Subject: Comments from KC PROW - 2025/91001 and 2024/93227

2025/44/91001/E

Land at, St Luke's, Bierley Marsh, East Bierley, BD4 6PL

Discharge of details reserved by condition 5 (access re-surface) on previous permission 2020/94345 (APP/Z4718/W/21/3289729) for erection of 5 dwellings

client name			
Owens Developments Ltd			
project			
New Dwellings - Land at St Lukes.			
drawing			
Proposed Site Layout			
project number		plot date	
19/157		24/11/20	
drawing number		scale	
104		1:200 @A2	
rev		issue status	
D		Planning Submission

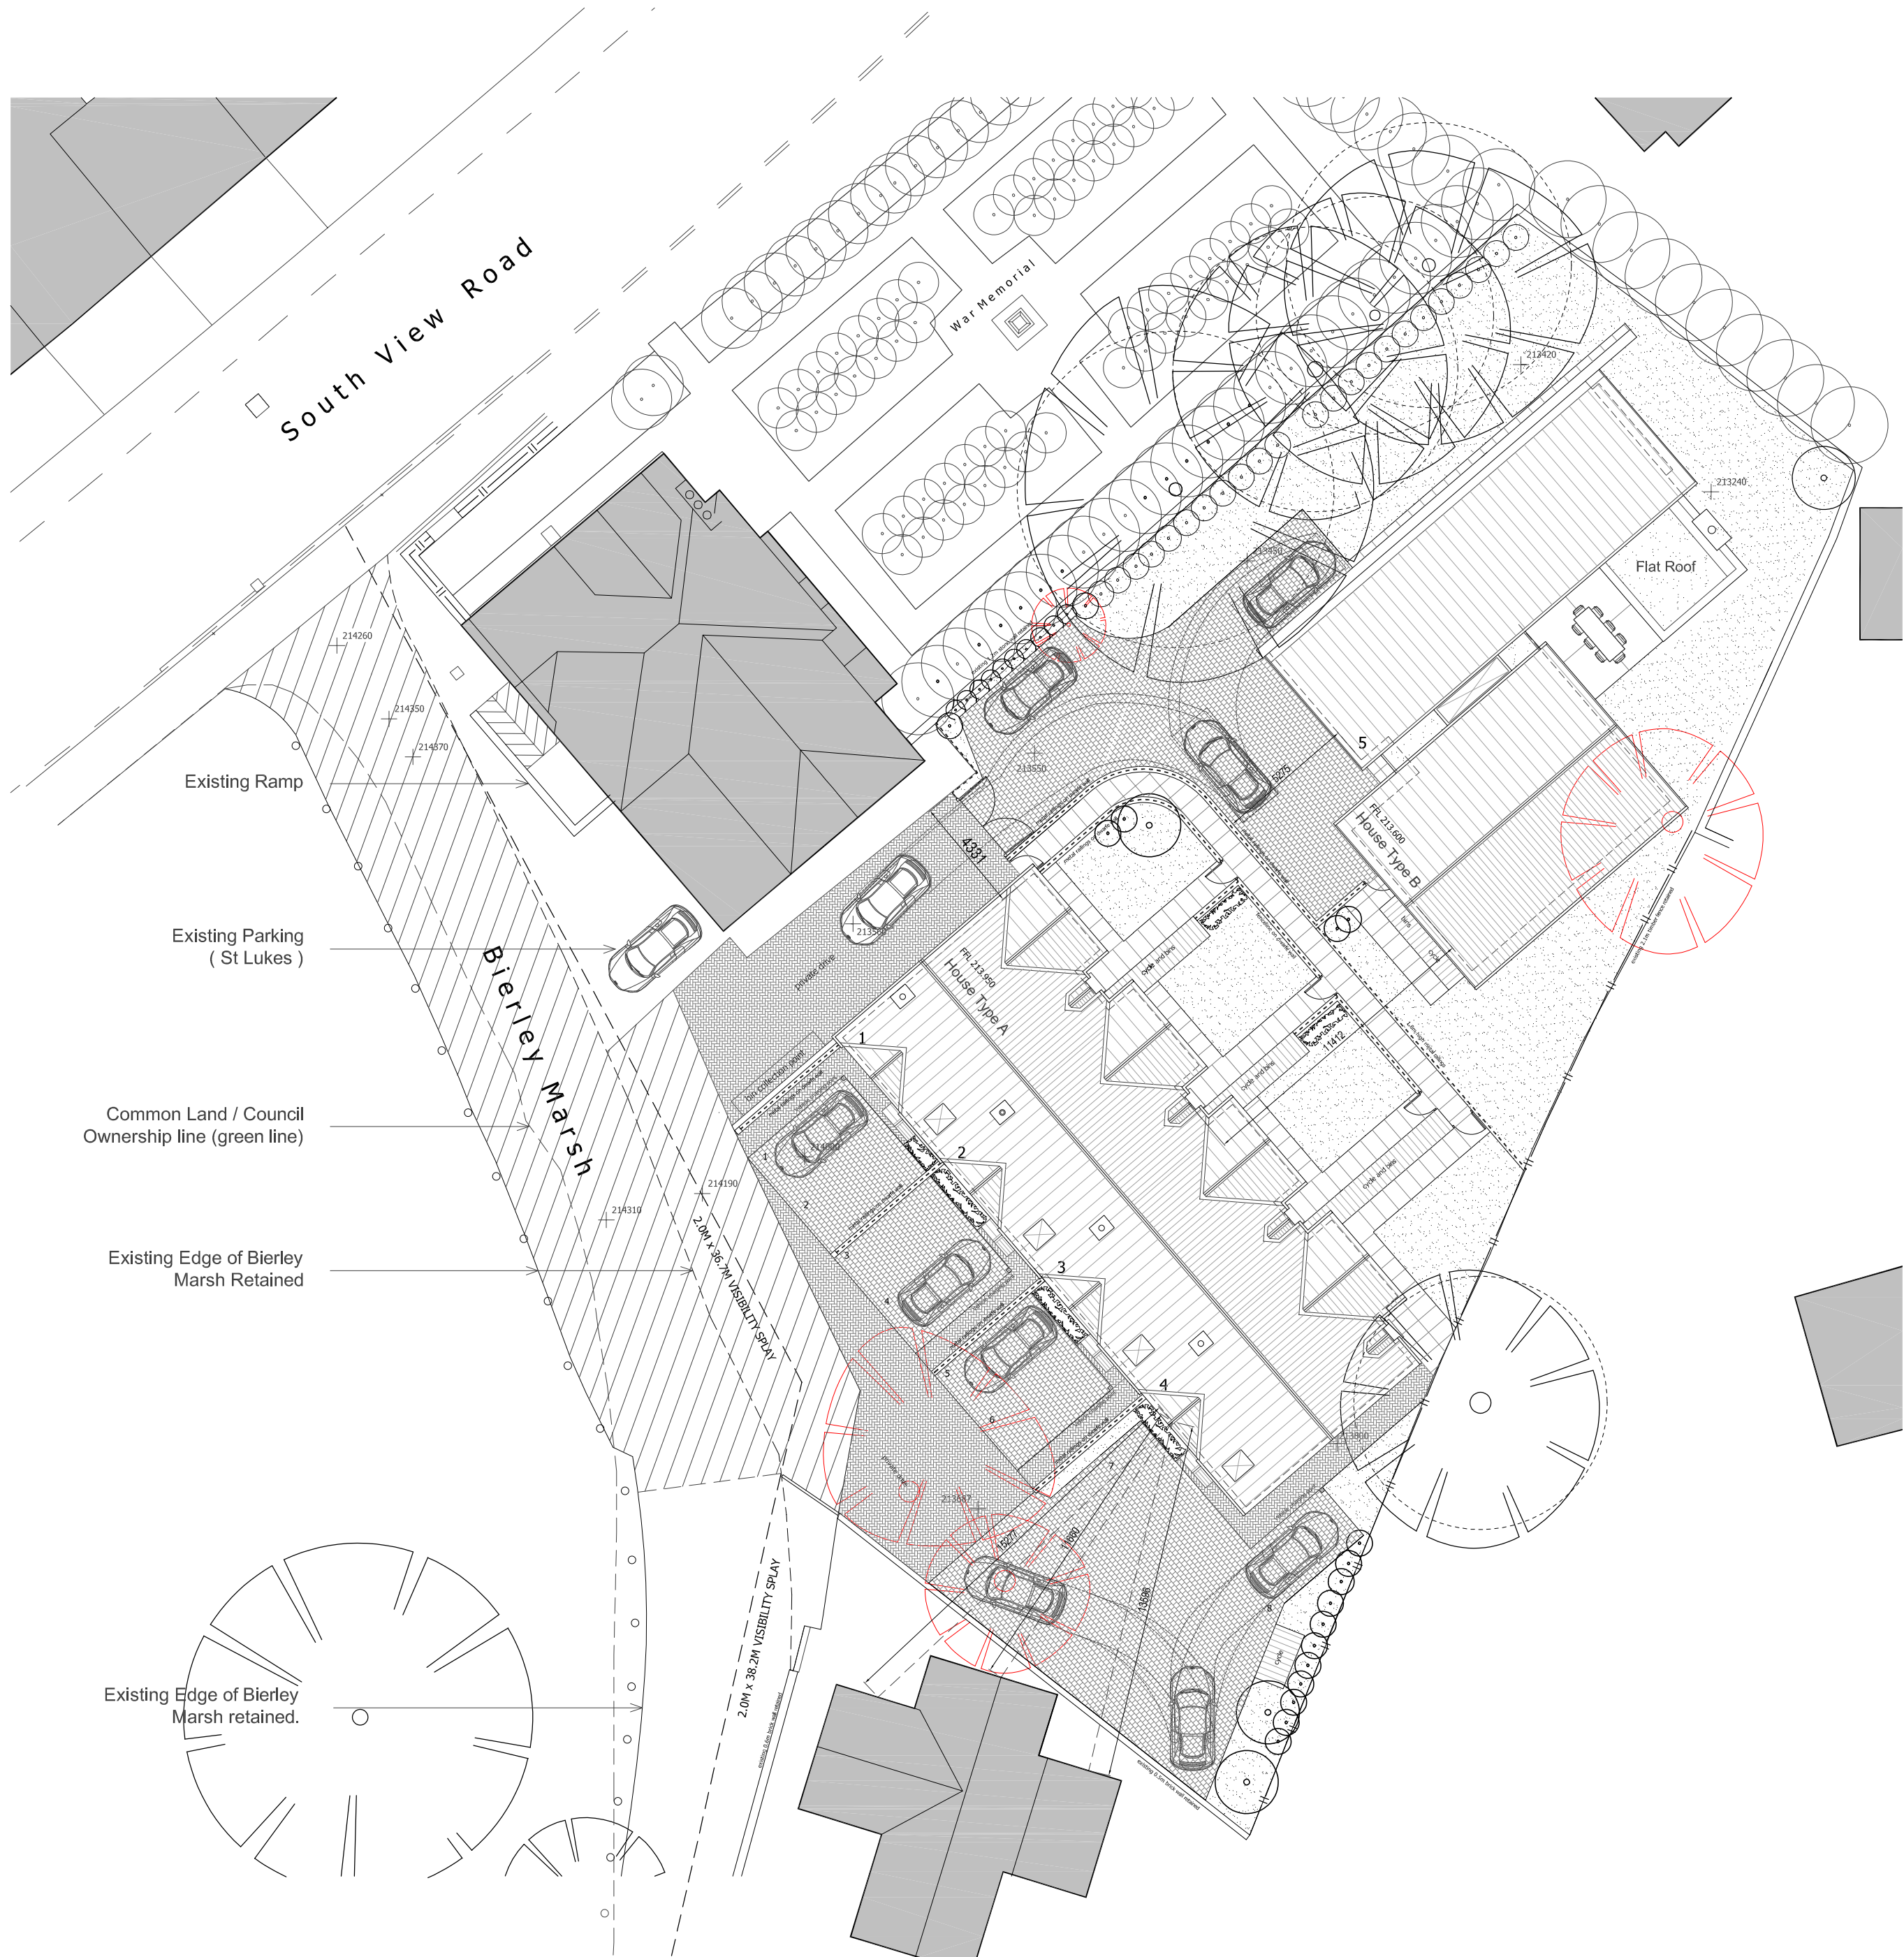
Public footpath SPE/6/20 runs along the access road (part of Bierley Marsh) that will serve the development. In addition to carrying a public footpath the road currently provides vehicular access to various existing properties. The existing access road along which FP SPE/6/20 runs currently has a sealed surface. KC PROW does not object to the resurfacing of SPE/6/20 in the manner shown on drawings 104 F, MCB/24/018/0701 and MCB/24/018/0201. However, for the benefit of the applicant, other landowners who take access over Bierley Marsh, and officers in other teams, the following additional observations are made regarding the widening / resurfacing of Bierley Marsh.

Over time a strip of land on the east side of the common land, where it abuts the west side of SP/6/20, had become used informally for the parking of vehicles. At some point this strip has been resurfaced with asphalt and / or gravel. Posts were erected on the grass to prevent further encroachment by vehicles on to the village green. The current proposal shown in drawing MCB/24/018/0701 and other drawings includes proposed resurfacing, for use as part of the access road to previous approved development (2020/94345), of the strip of Kirklees-owned common land as far west as the existing line of posts. Consent from the vesting service would likely be required for any works, also in respect of the granting of an easement.

The consent of the Secretary of State may be required, under section 38 of the Commons Act 2006, to carry out works including resurfacing of part of the common land. If appropriate the owner of the land may make an application to the Secretary of State for deregistration / exchange of common land.

Matters relating to private access rights, landowner consent, and consent from the Secretary of State in respect of common land, are all matters for the developer to address but which fall outside the planning application process.
